CONSTRUCTION DRAWINGS FOX RUN NATURE CENTER

EPC STORMWATER REVIEW COMMENTS
IN ORANGE BOXES WITH BLACK TEXT

EL PASO COUNTY PARKS
FOX RUN NATURE CENTER
DRIVEWAY & PARKING AREA GRADING PLAN

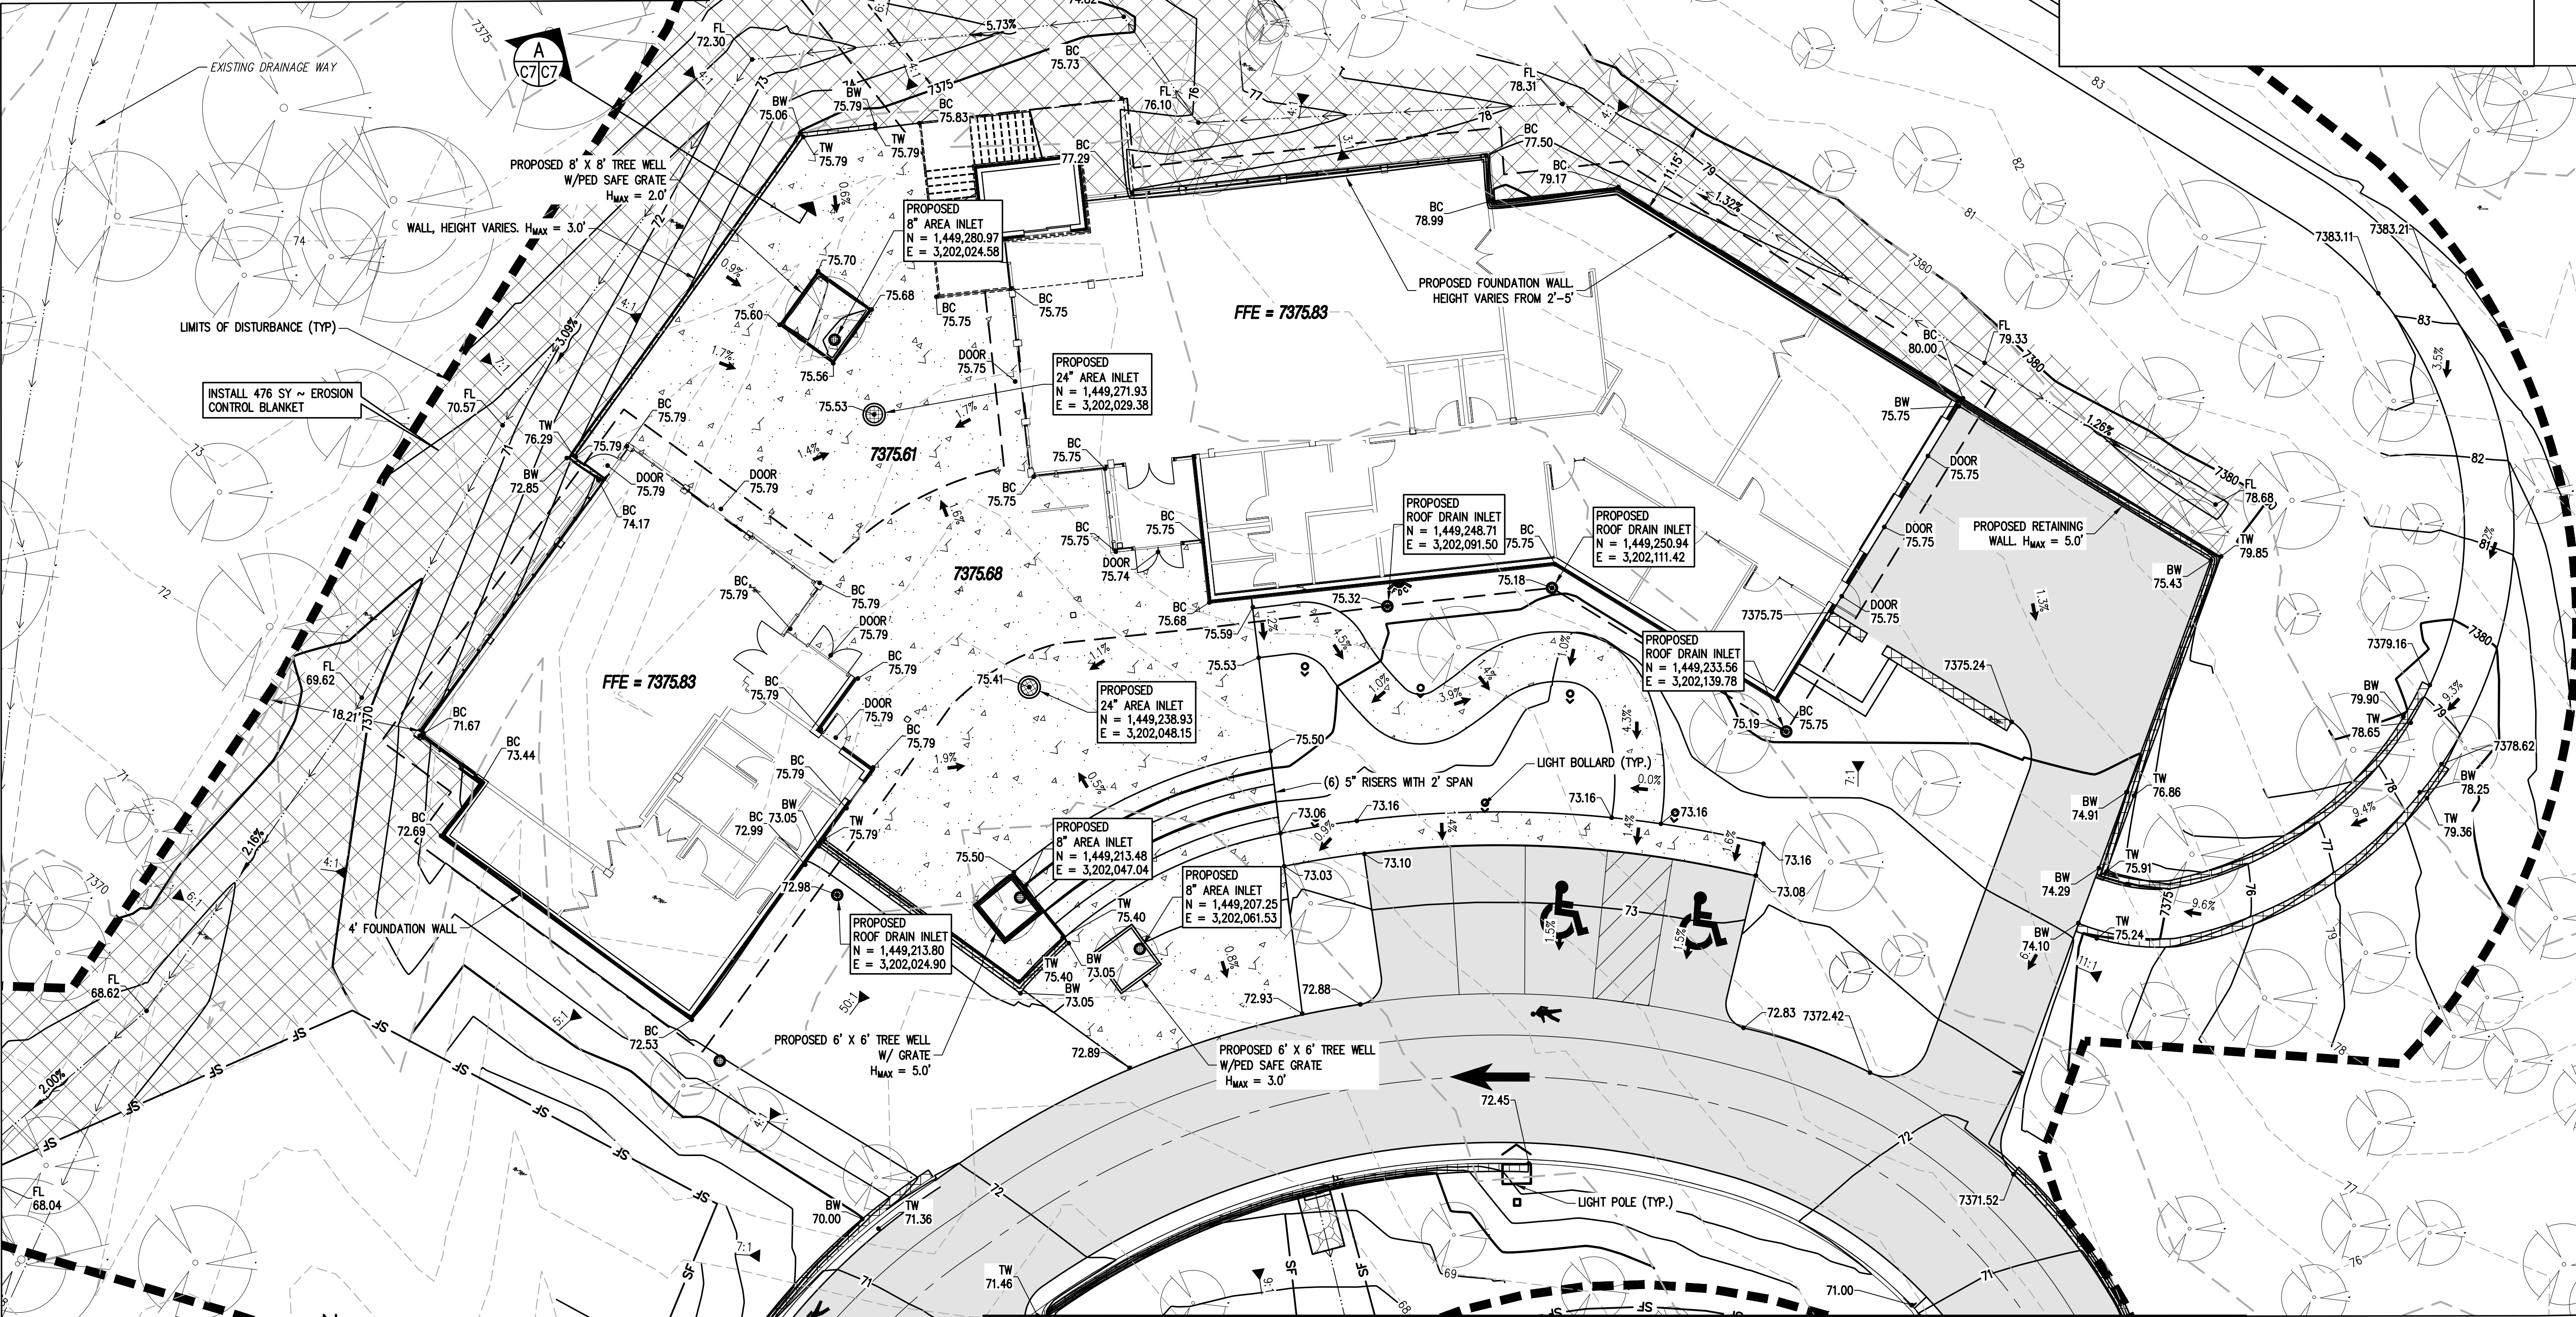
Please include all appropriate linework in the legend and turn off unneeded linework from this drawing

Please include the pavement section here

include paved width

C3

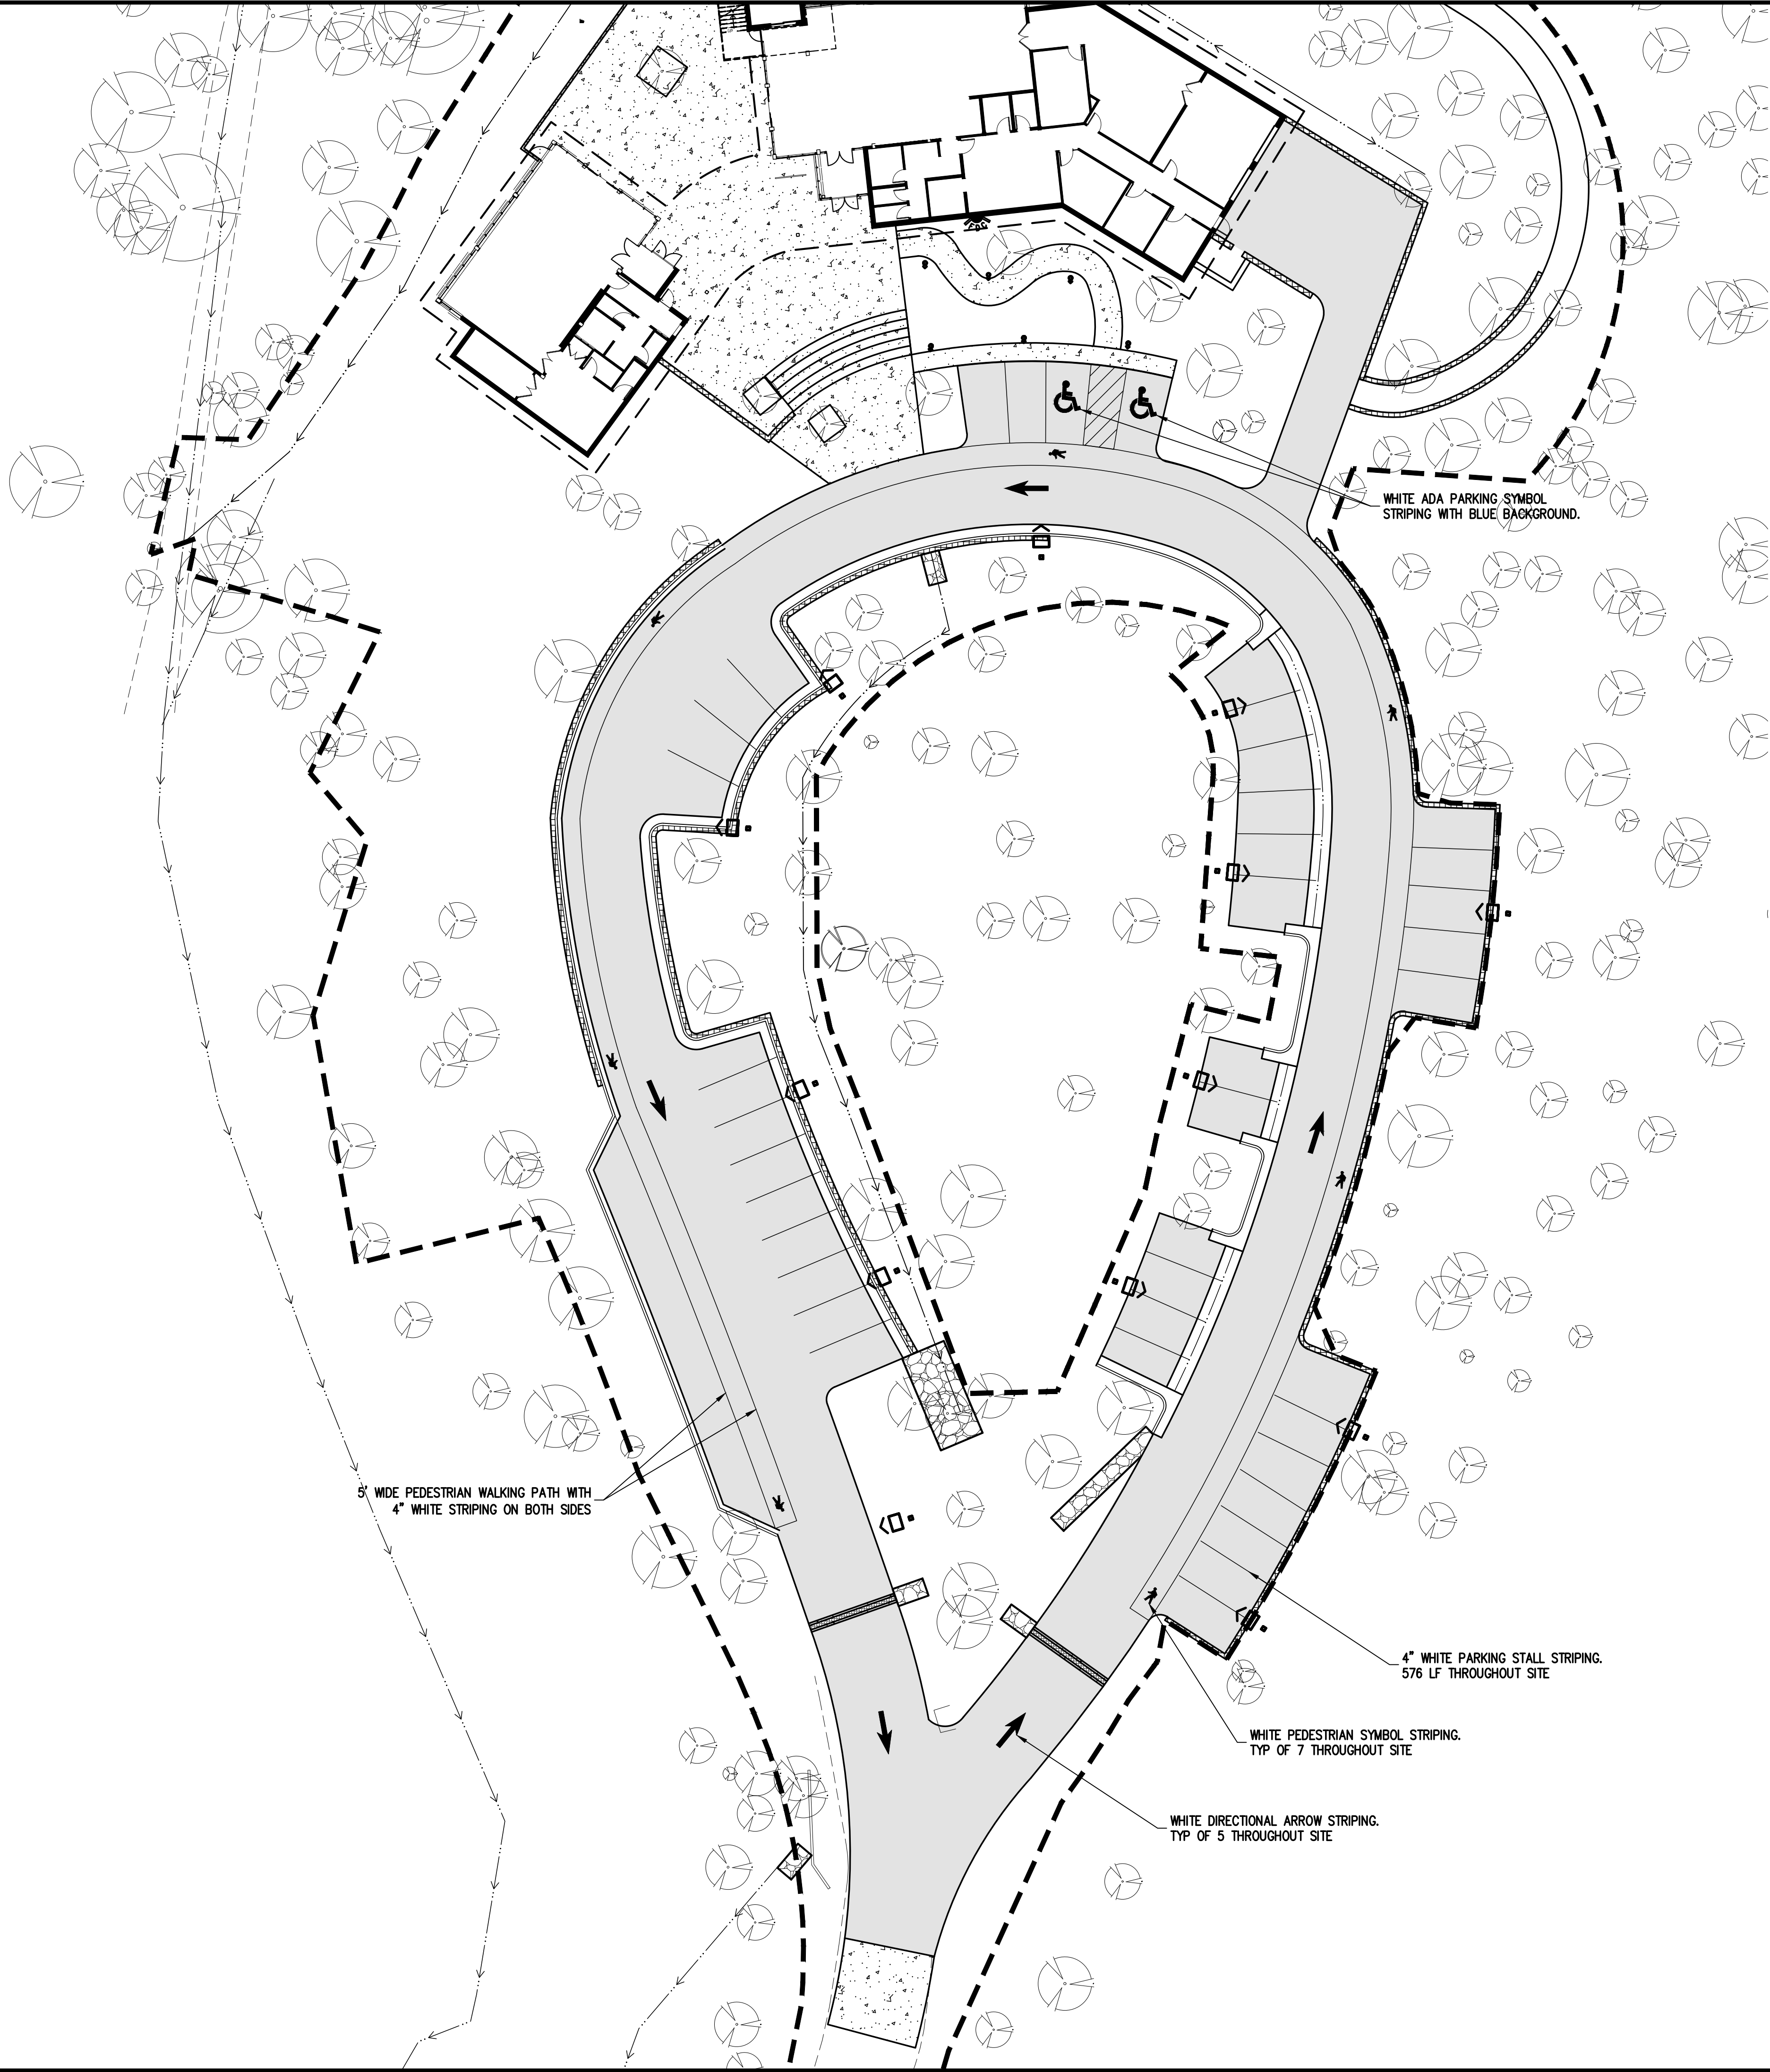
Please include the standard detail number
